Located At 35 SPAR LN

Job ID: 2011-08-2104-ALTR

Proposed Project Description: <b>Add 10' x 37' Deck</b>		Pedestrian Activities District (P.A.D.)	
Permit Taken By:		<b>Zoning Approval</b>

## **Conditions of Approval:**

ELEVATION FOR  
DECK  
35 SPAR LN  
PORTLAND 04102

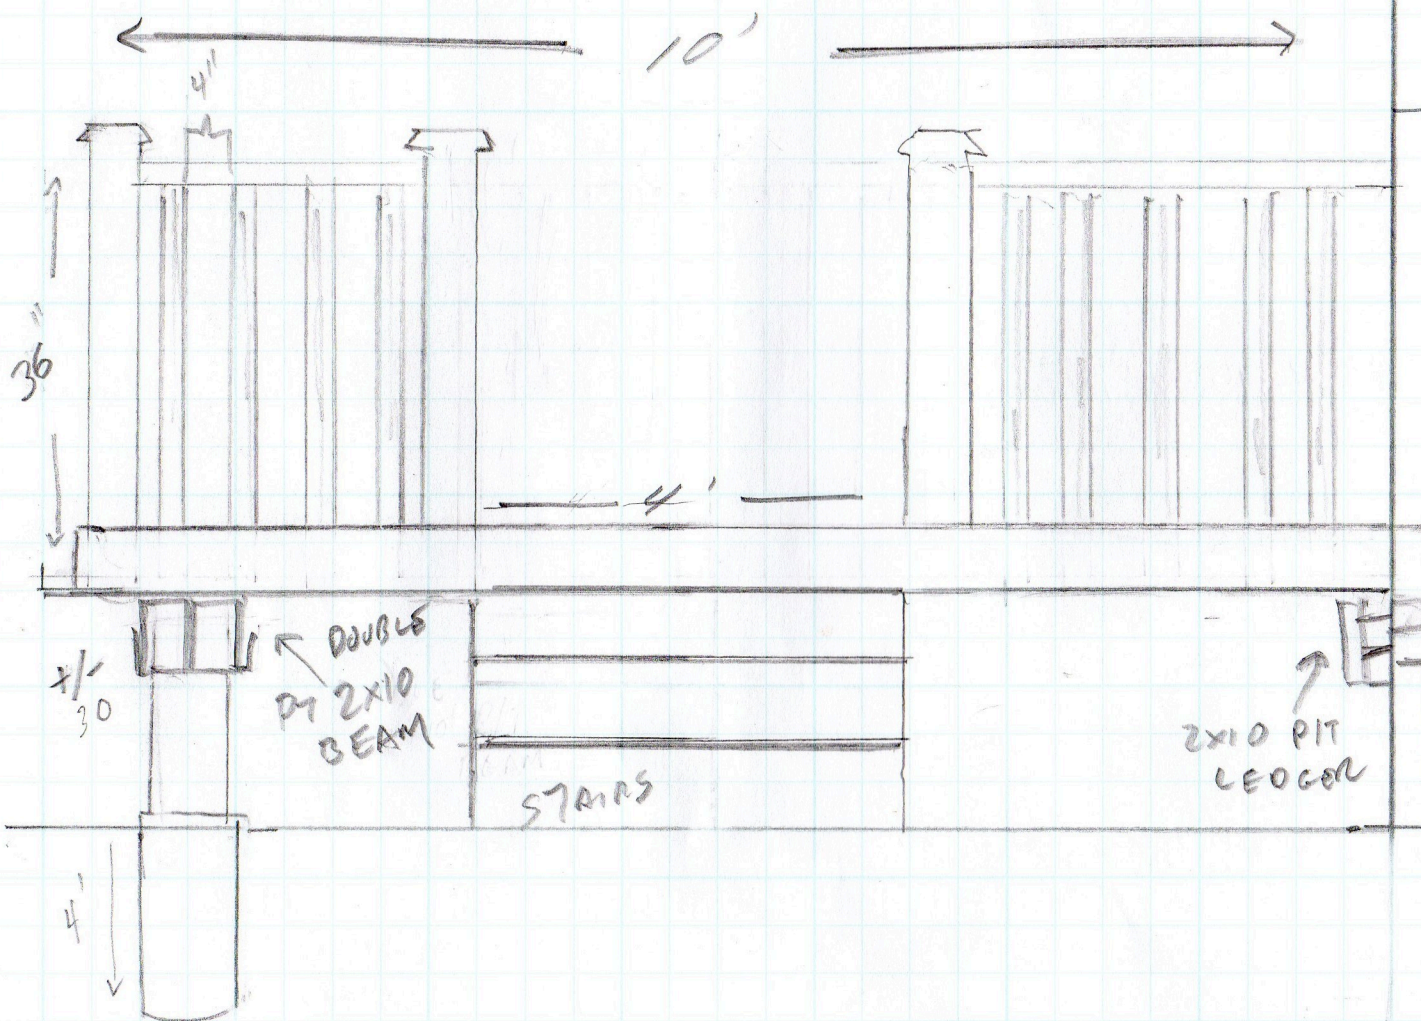
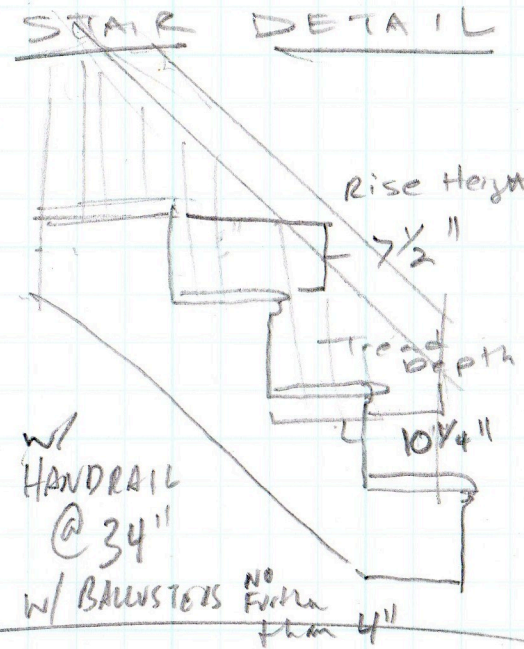
1. Application approval based upon information provided by applicant. Any deviation from approved plans requires separate review and approval prior to work.
2. Permit approved based on the plans submitted and reviewed w/owner/ contractor, with additional information as agreed on and as noted on plans, regarding graspable handrail.
3. Detail required on the deck attachment to the existing 13' porch for review.
